From: Sue Howell
Sent: 05 March 2015 18:05
To: Anita Gardner
Subject: RE: Planning Consultation on: LU/13/15/PL

Comment from Greenspace

Site Address: The Old Dairy Behind 3 & 5 Church Street
Littlehampton BN17 5EL

Description of Works: Demolition of original dairy distribution depot and construction of eight dwellings and ancillary works. This application may affect the character and appearance of the Littlehampton (East Street) Conservation Area.

SITE PLAN WITH DRAFT LEVELS + ROOF PLANS AS PROPOSED
PROPOSED RESIDENTIAL DEVELOPMENT
THE OLD DAIRY . CHURCH STREET . LITTLEHAMPTON . SUSSEX .
GRAHAM NICOLLS LIMITED . DESIGN + TECHNOLOGY . TEL / 07990 522709

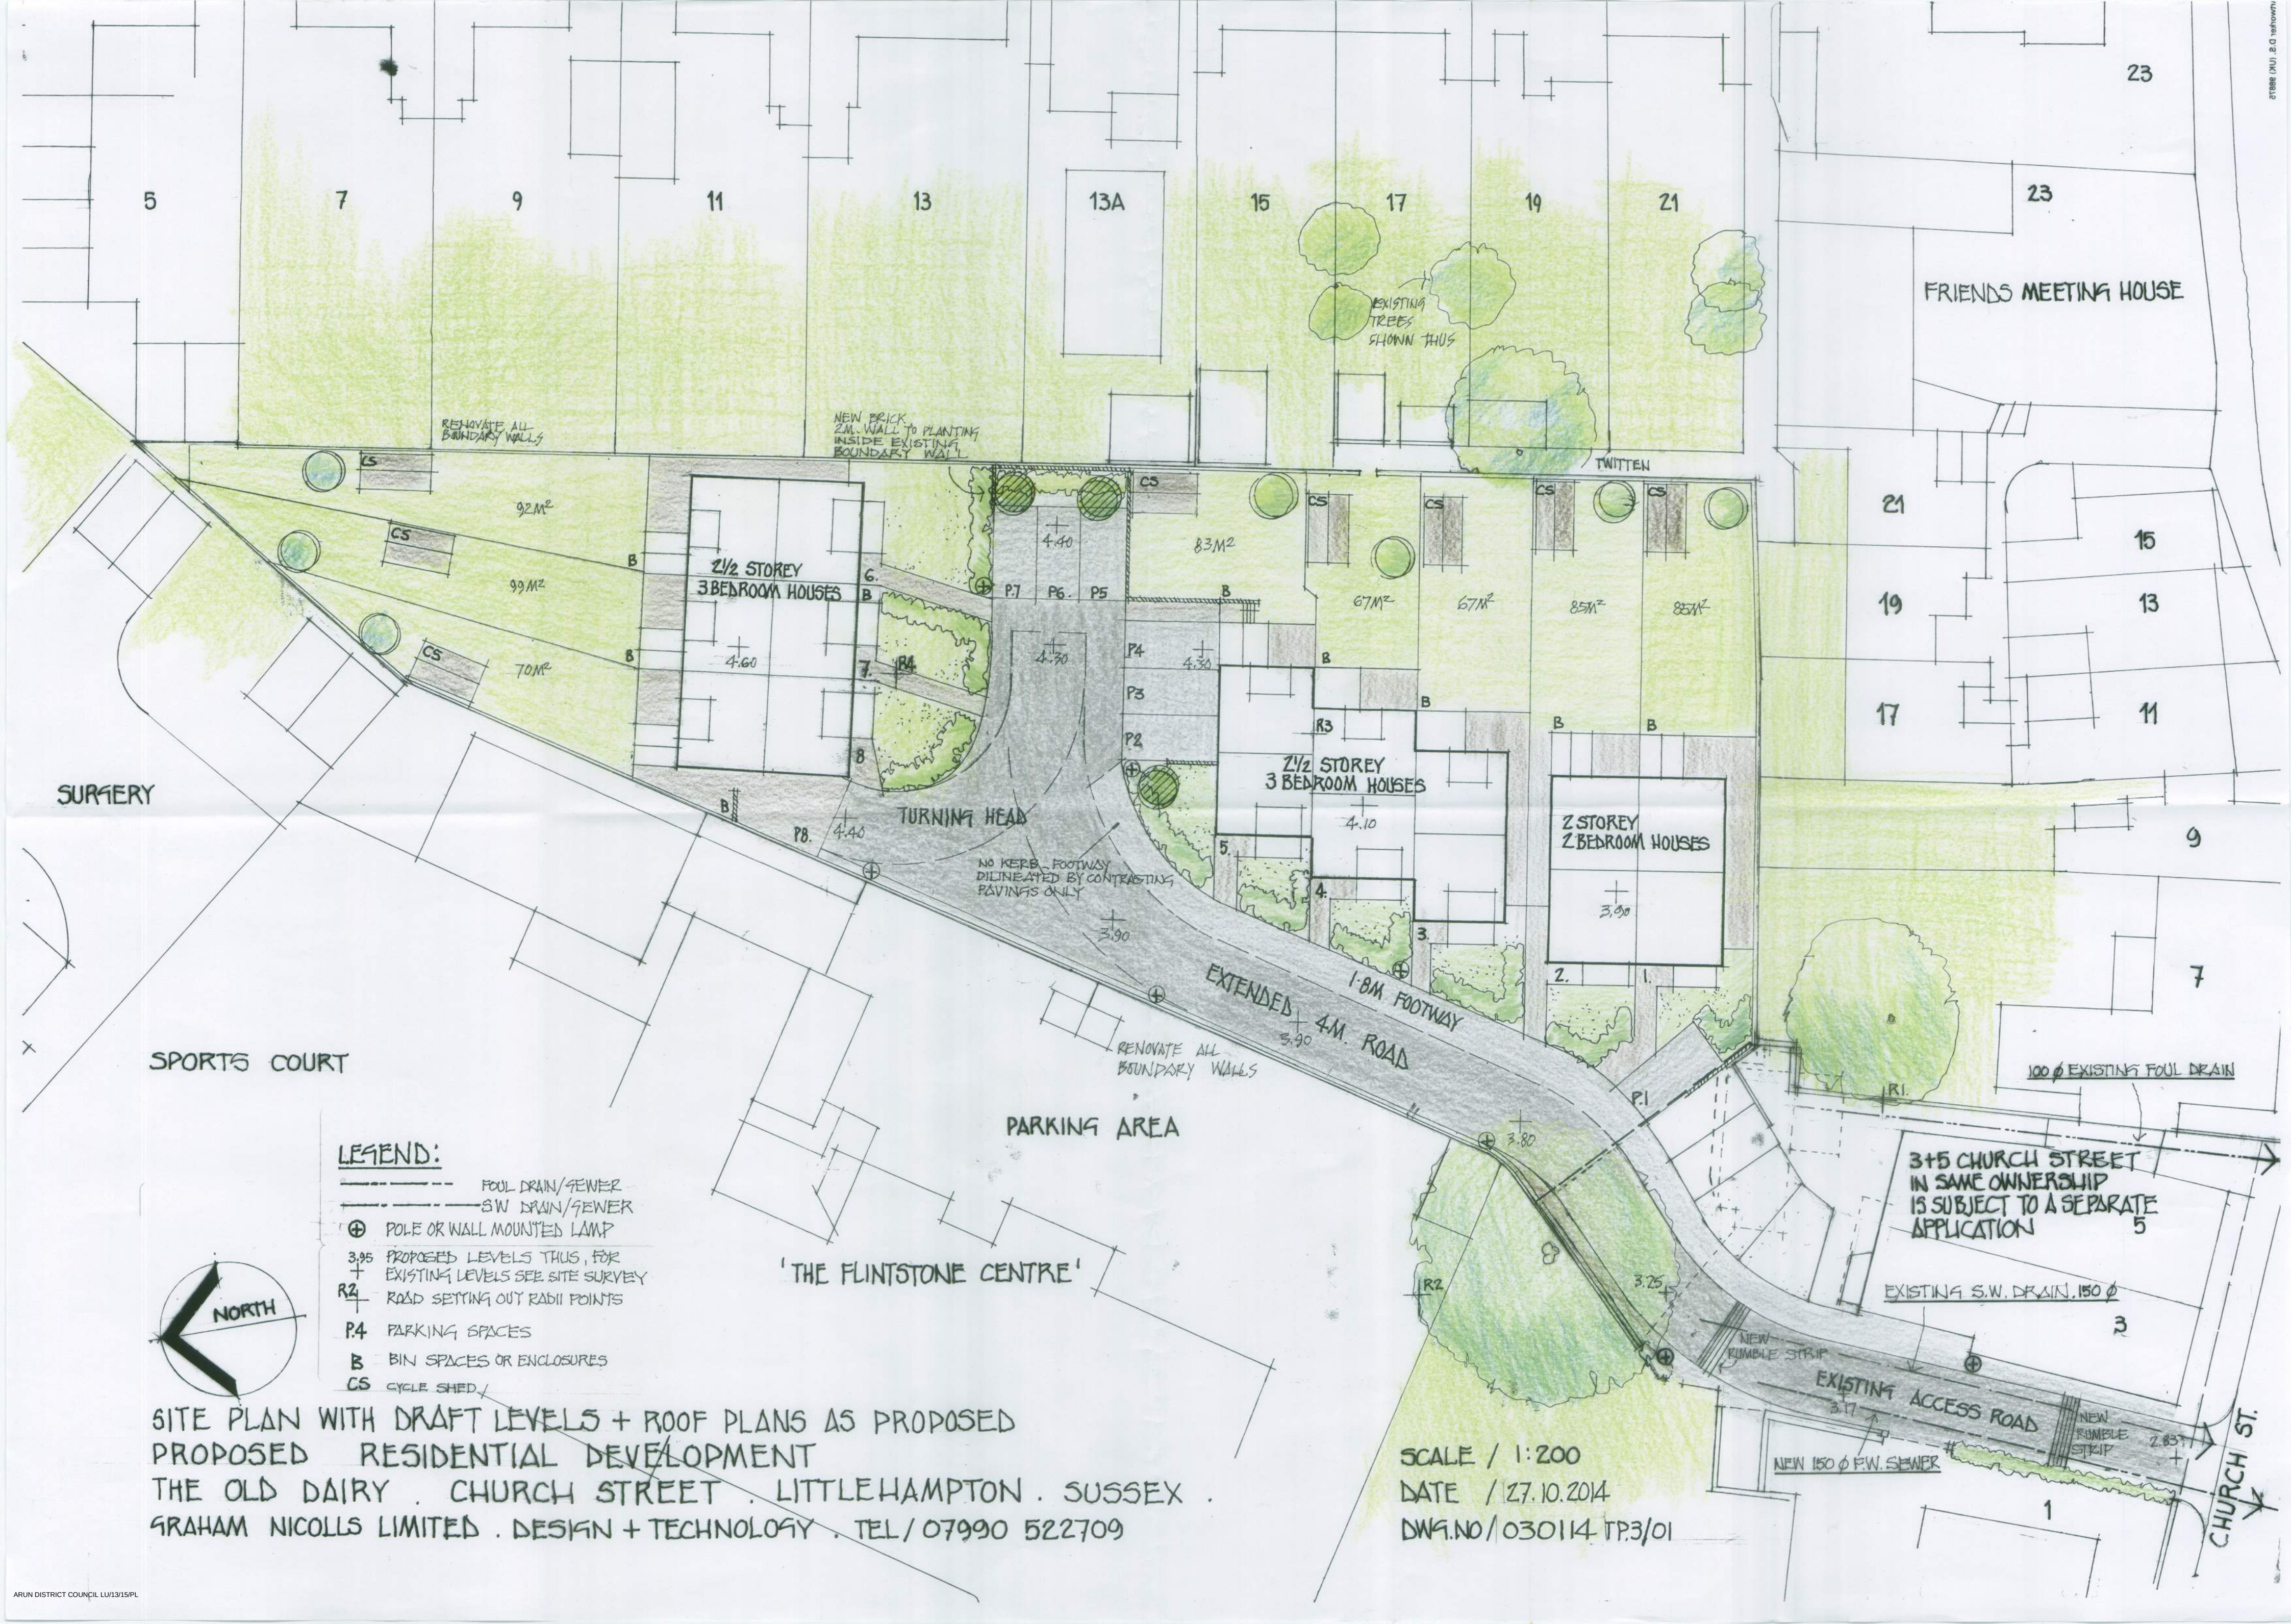
On a development of this size the ADC supplementary planning guidance states that landscaped open space provision should be made on site, as this is not indicated on the layout plans we would require a sum of £1000.00 per property to offset this. This would be a commuted sum towards play provision facilities, this would be for offsite provision for local play area improvements.

Prior to any consent being given a full landscape scheme should be submitted for approval, detailing species choice, position, densities and size at time of planting. This should be plotted in plan and list form so that a clear picture of the proposals can be seen. These details are required to assure the adjacent properties privacy is maintained and the setting is uncompromised.
